Five Estuaries Offshore Wind Farm

Appendix I3 to the Natural England Deadline 3 Submission
Natural England's comments on Seascape Landscape Visual Assessment Wirelines
and Updated Viewpoints [PD4-010 to PD4-012] and [REP2-031 to REP2-038]

Planning Inspectorate Reference EN010115

12 November 2024

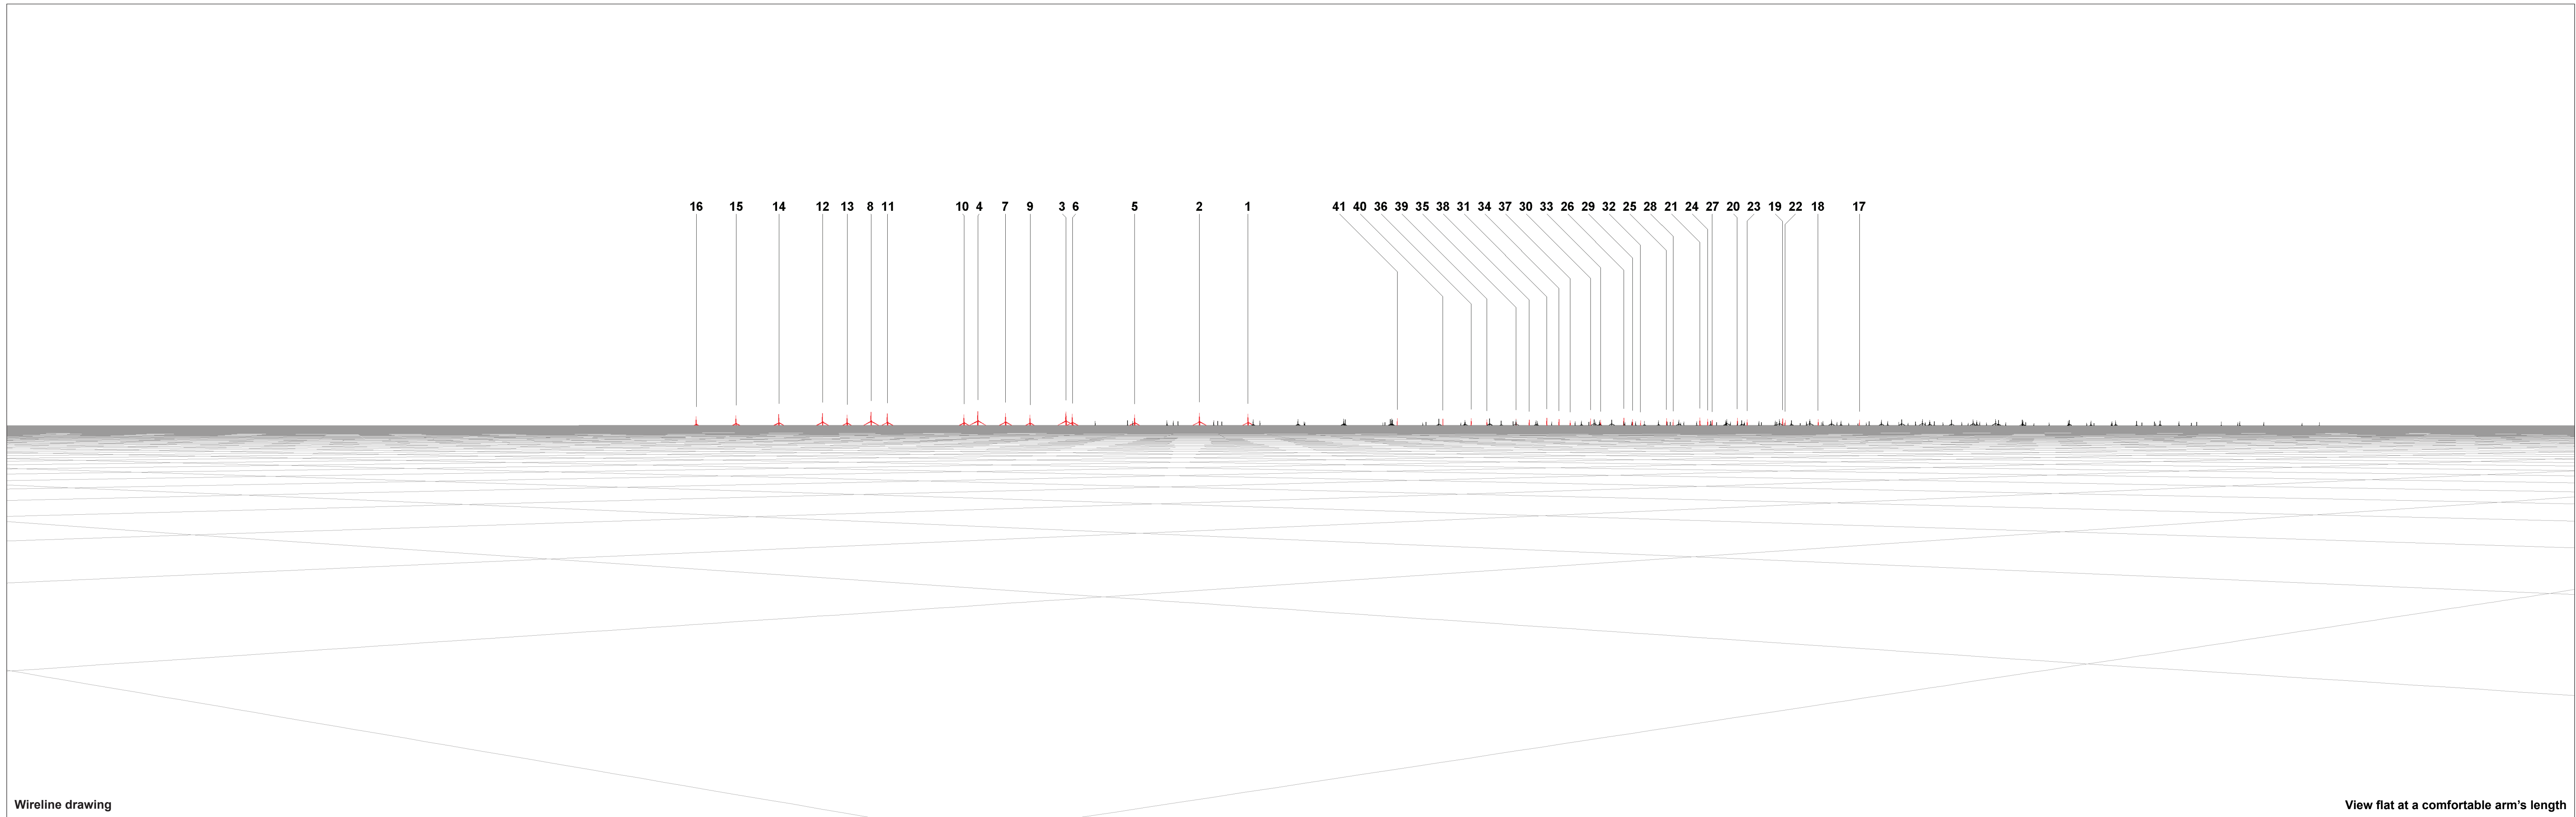
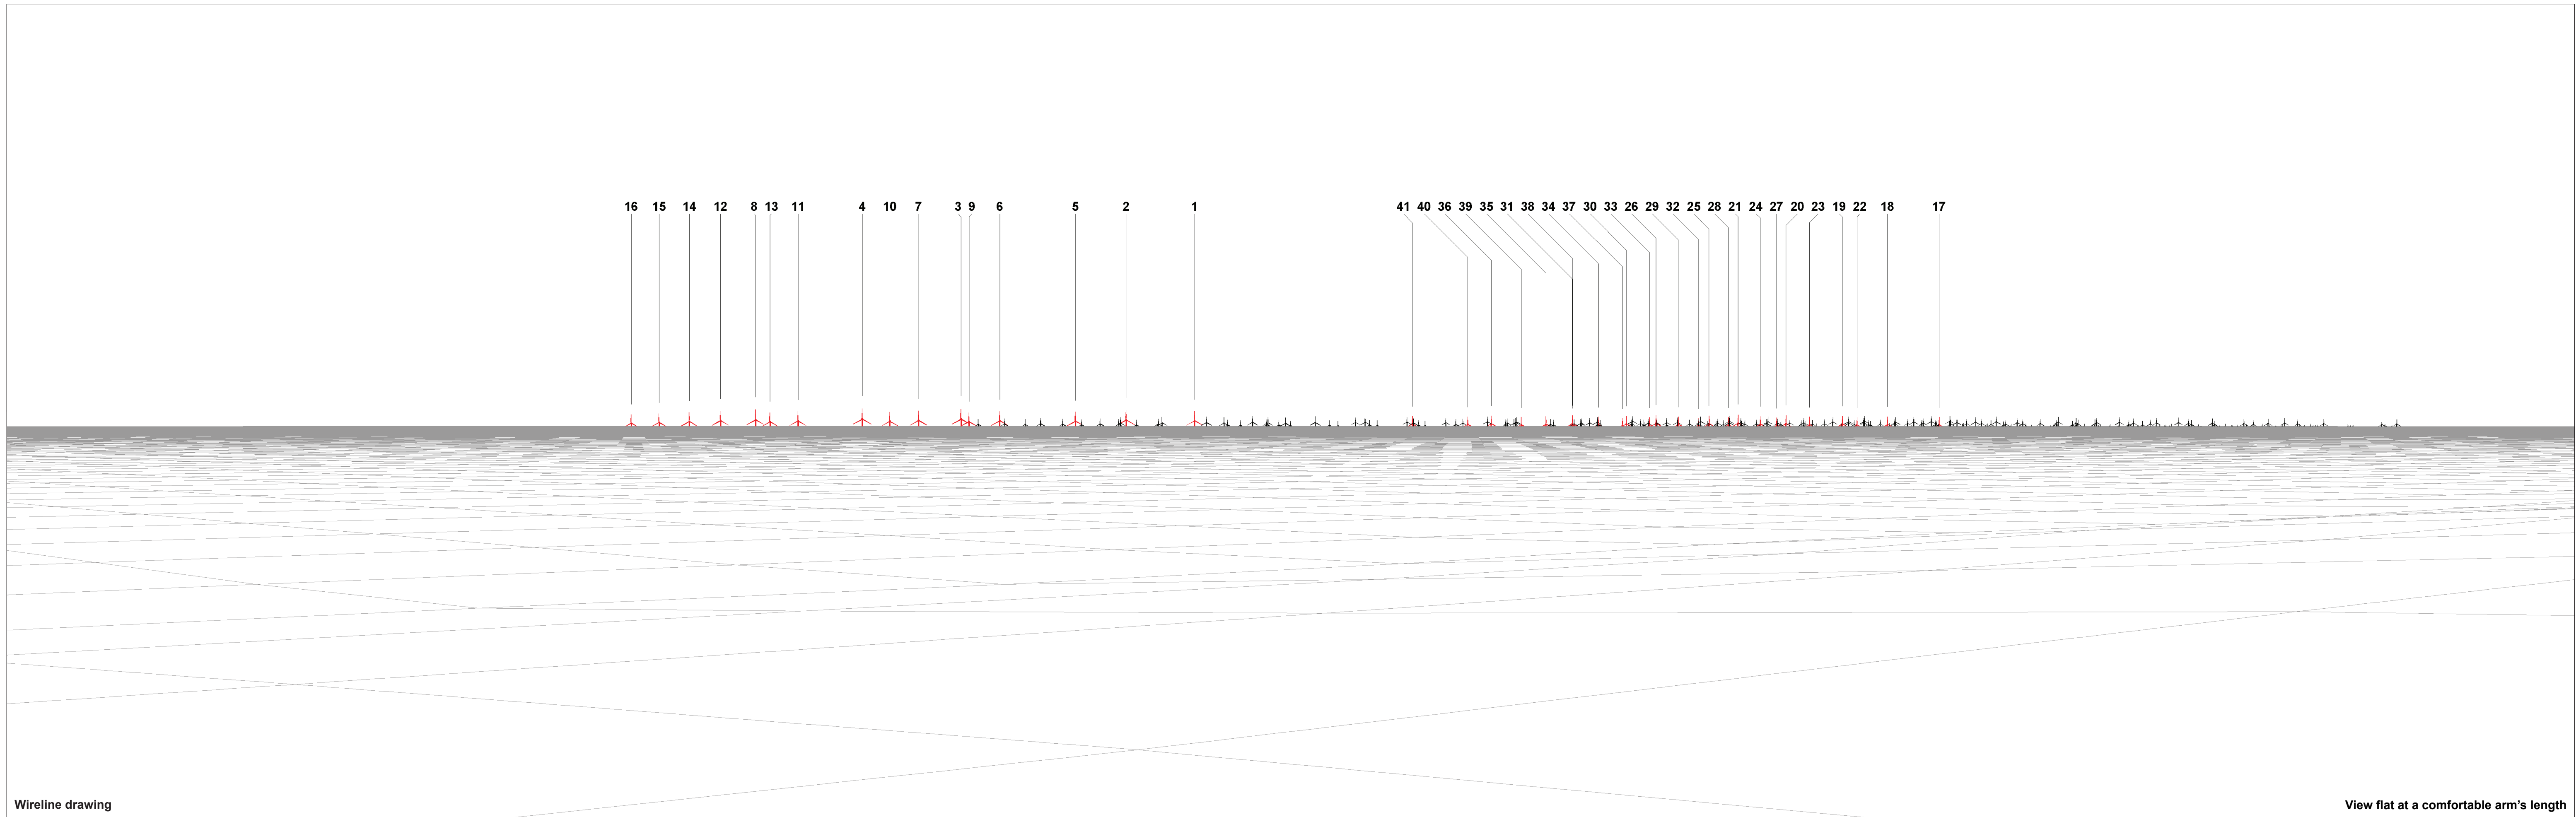
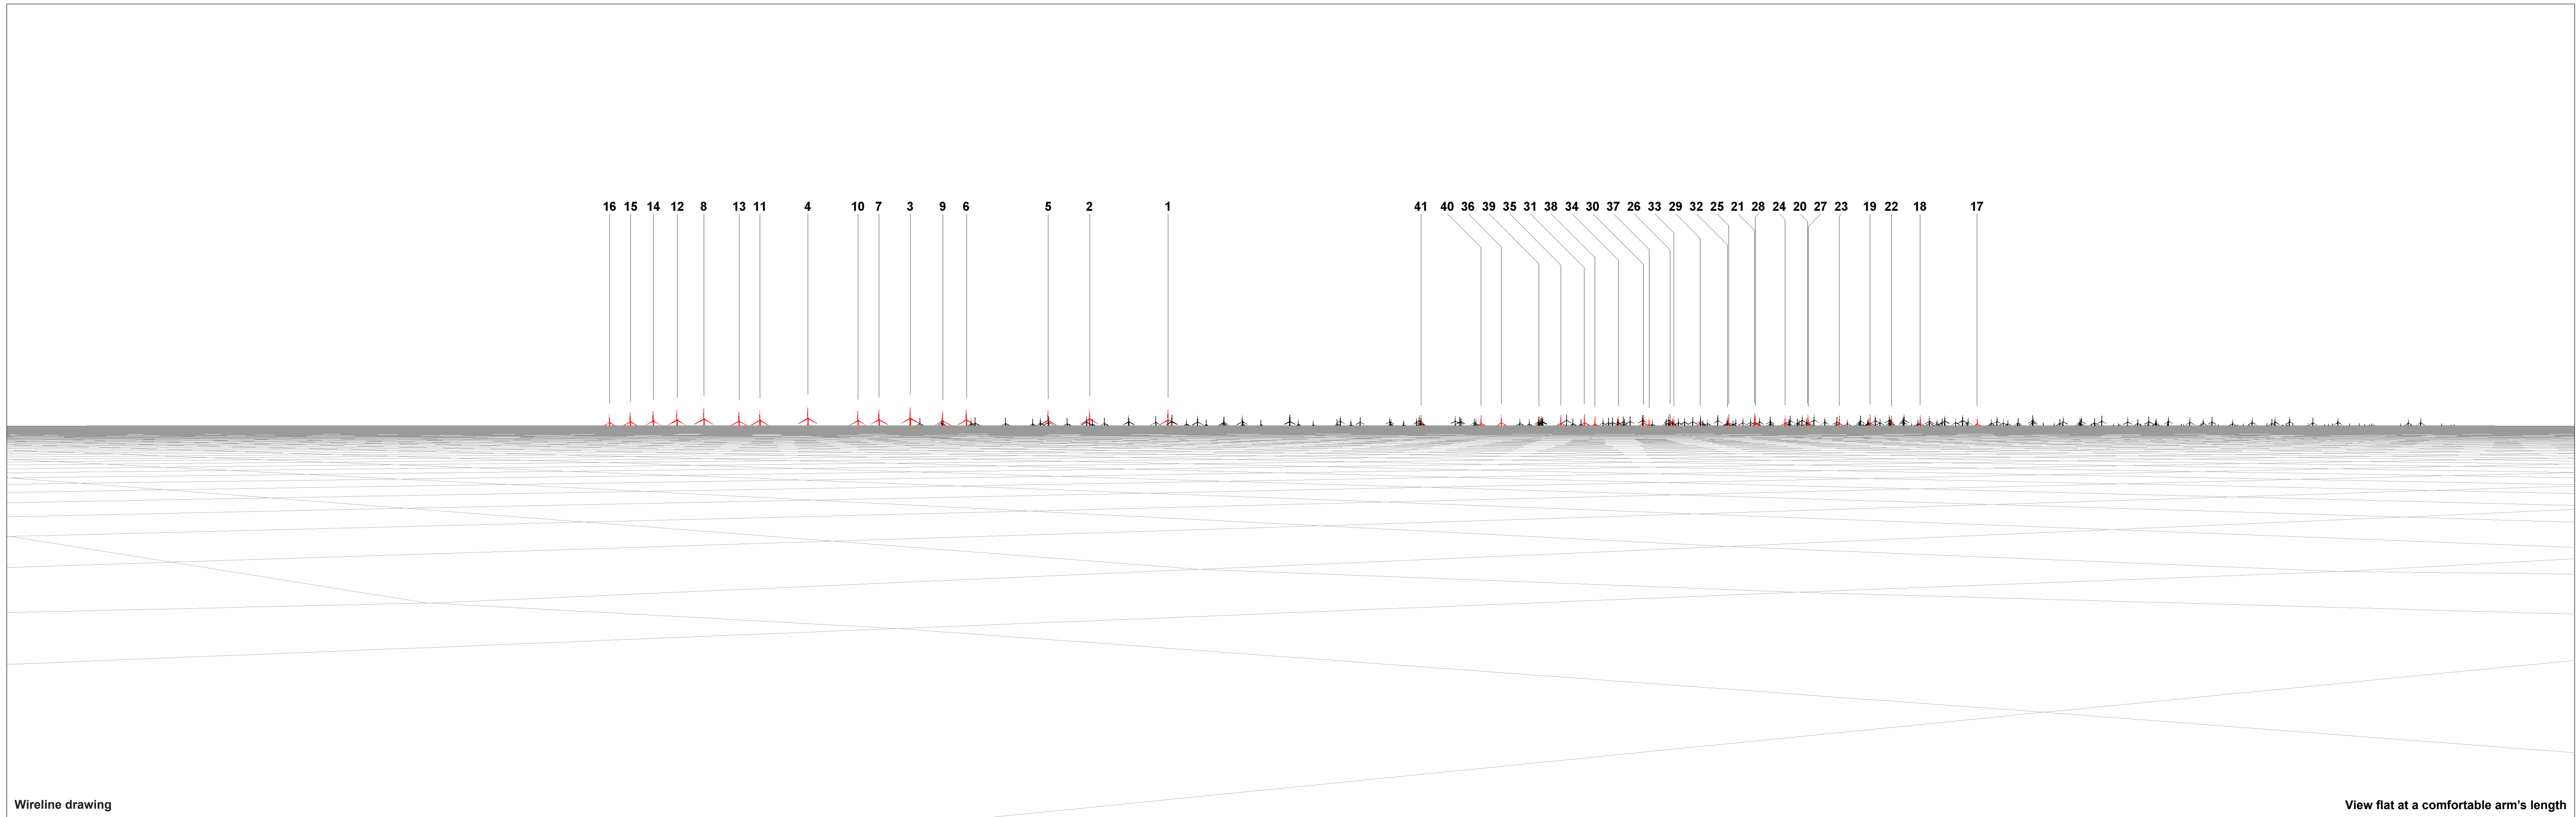
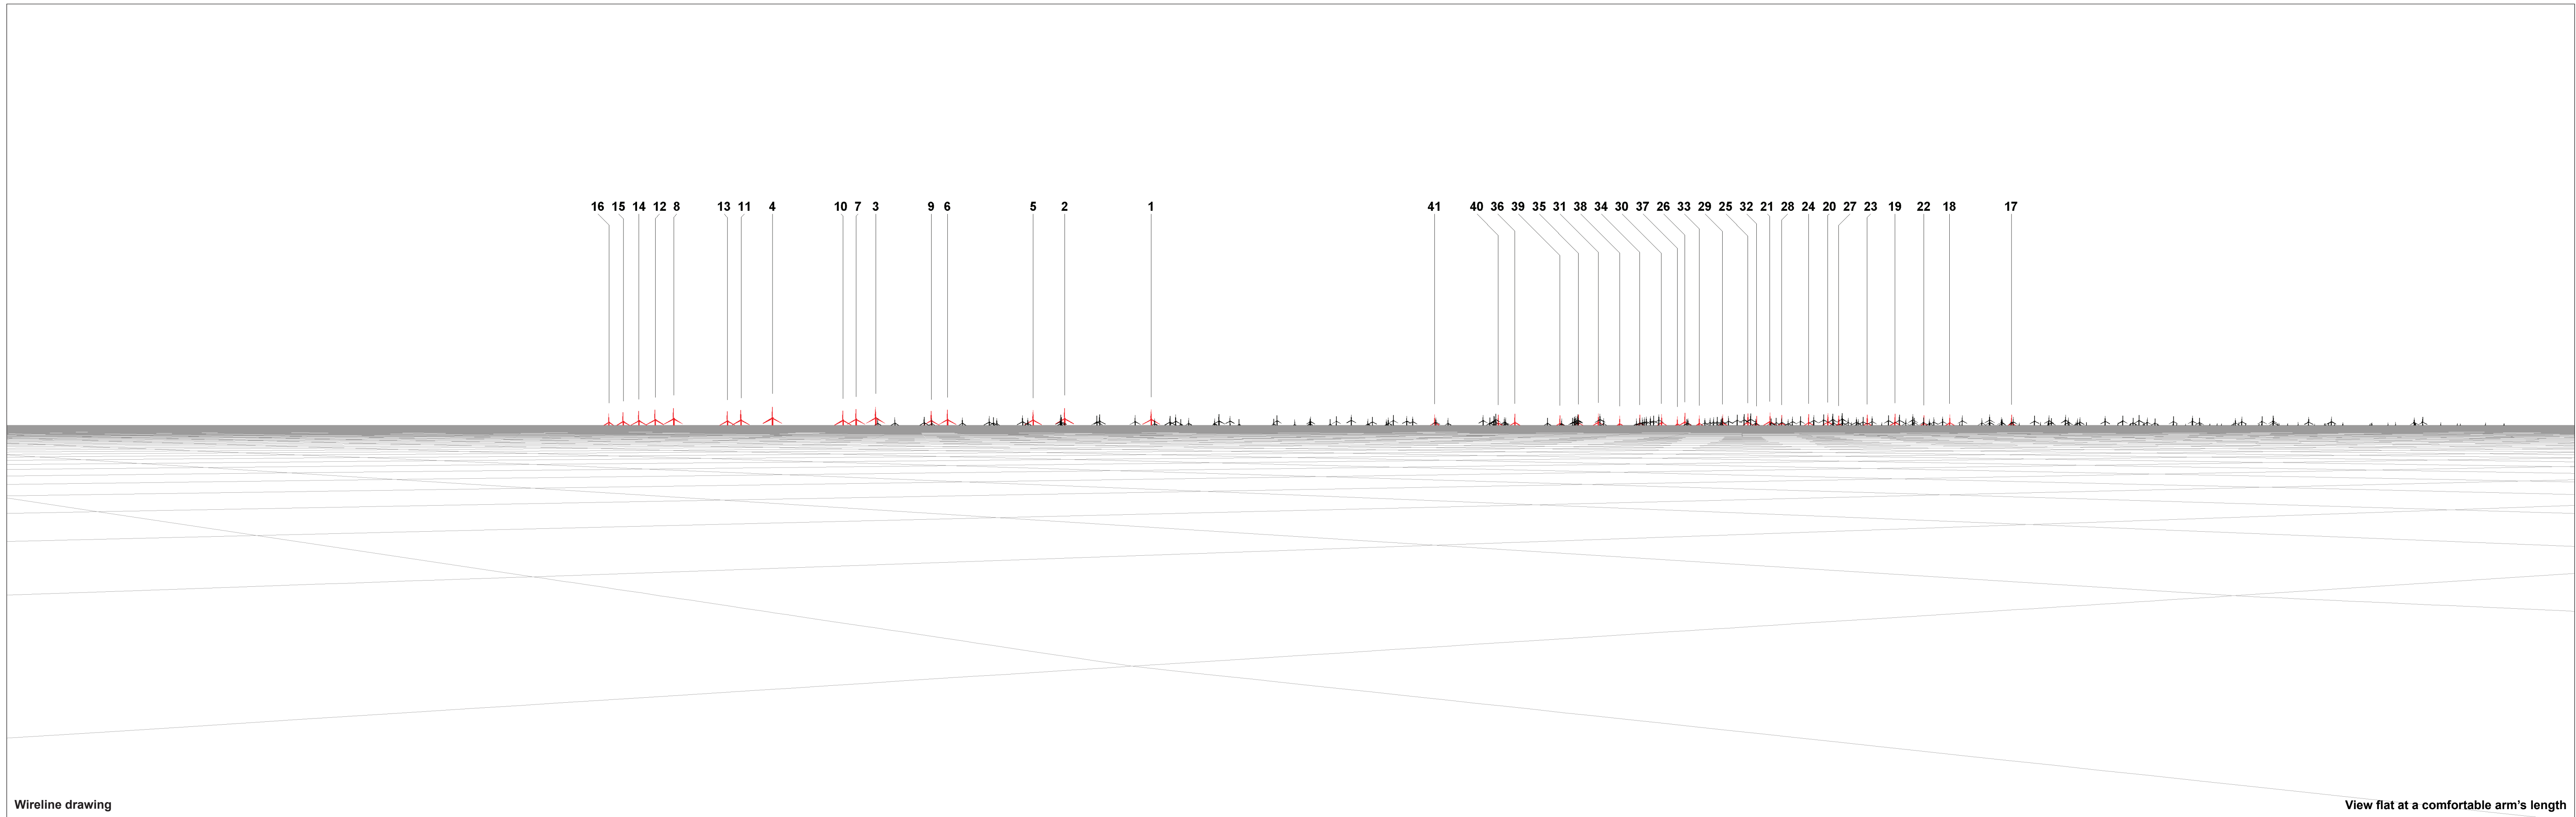
Document reviewed: [REP2-031 to REP2-038] 10.21.1 to 10.21.8 Updated SLVIA Viewpoints 1-6, 9 and 10 (Figures 10.26 to 10.31, 10.34 and 10.35) – 370m Tip Height			
NE Ref	Section	Key Concern and/or Update	Natural England's Advice to Resolve Issue
1	General Comment	The viewpoints chosen for updated wireframes for 370m LAT option are the key viewpoints within the SCHAONB. The 29m reduction in the height to turbine blade tip has not changed Natural England's advice in relation to the significance of seascape and visual effects associated with the statutory purposes of the SCHAONB, SHC, and their seascape settings.	Natural England's advice remains unchanged.
